City of Portland, Maine - Building or Use Permit Application
 389 Congress Street, 04101 Tel: (207) 874-8703, Fax: (207) 874-8716

Permit No: 06-1269	Issue Date:	CBL: 298 A032001
------------------------------	--------------------	----------------------------

Past Use: Split off Vacant Land	Proposed Use: New Single Family Home/ Split lot from 82 Belfort to build single family, fully dormered cape w/ one story garage	Permit Fee: \$1,535.00	Cost of Work: \$144,000.00	CEO District: 5
Proposed Project Description: Split lot from 82 Belfort to build single family, fully dormered cape w/ one story garage		FIRE DEPT: <input type="checkbox"/> Approved <input type="checkbox"/> Denied	INSPECTION: Use Group: Type	
		Signature:	Signature:	
PEDESTRIAN ACTIVITIES DISTRICT (P.A.D.)				
Action: <input type="checkbox"/> Approved <input type="checkbox"/> Approved w/Condition <input type="checkbox"/> Denied				
		Signature:	Date:

Dept: Zoning **Status:** Approved with Conditions **Reviewer:** Ann Machado **Approval Date:** 09/18/2006

9/12/06

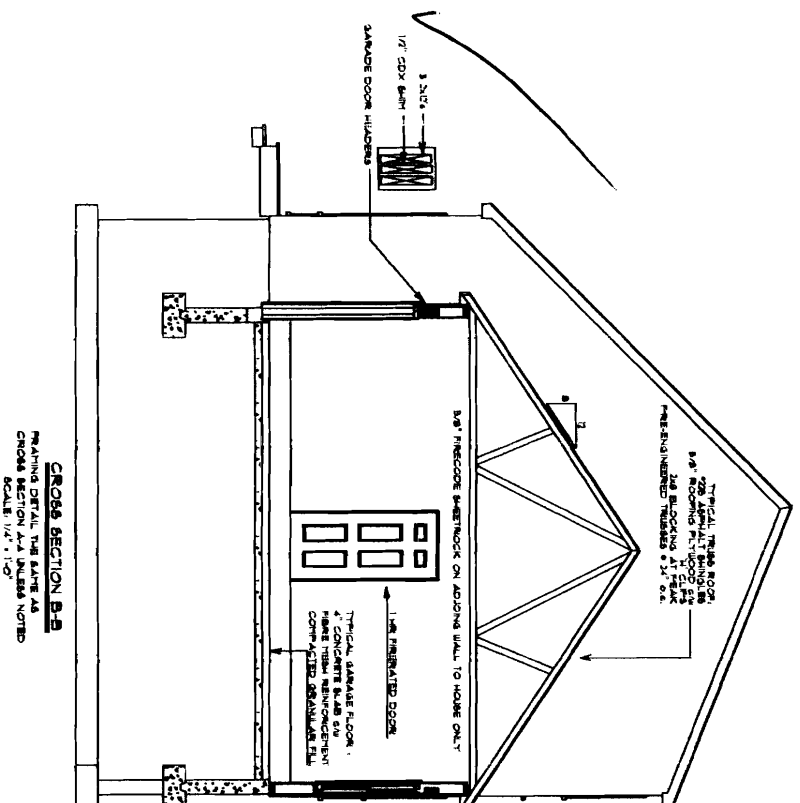
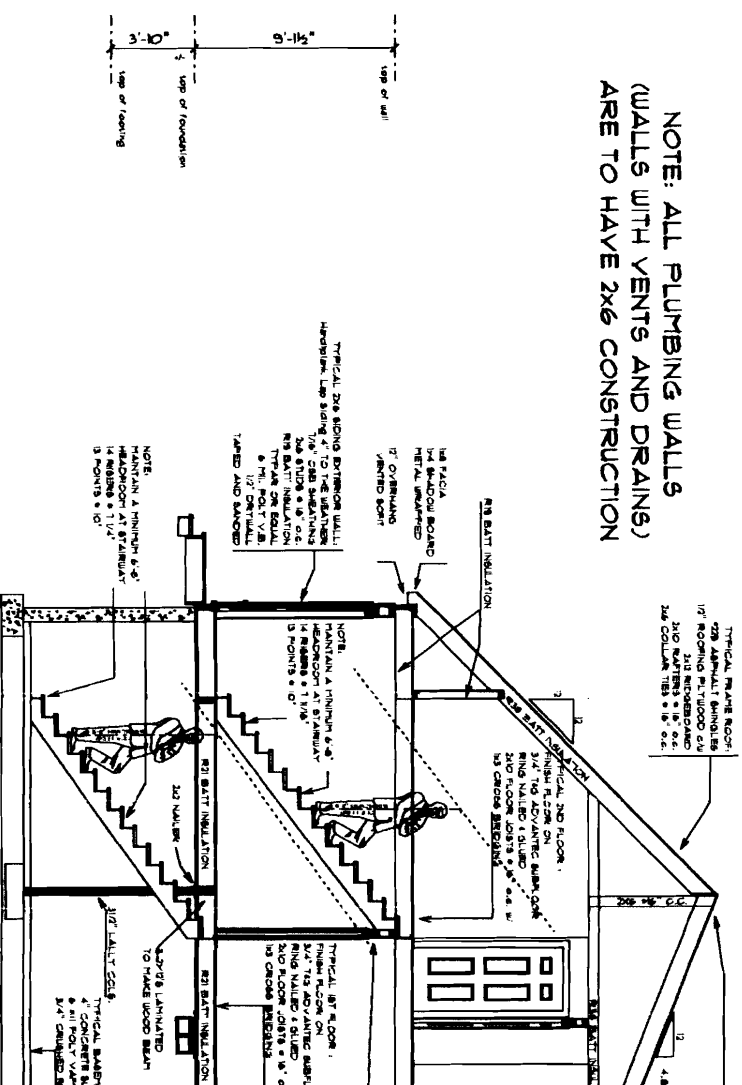
9/13/06-amachado: Michael Rogers brought in new building plans that show that the garage is being reduced to 11' wide but we need a revised plot plan that shows the new building footprint and how it is meeting the setbacks.

9/5/06-amachado: Left message with Michael Rogers, Casco Bay Development, LLC. House does not meet the side setback of 14' in the left rear corner.

9/18/06-amachado: Received revised plot plan from Jay Reynolds which matches the revised building plans.
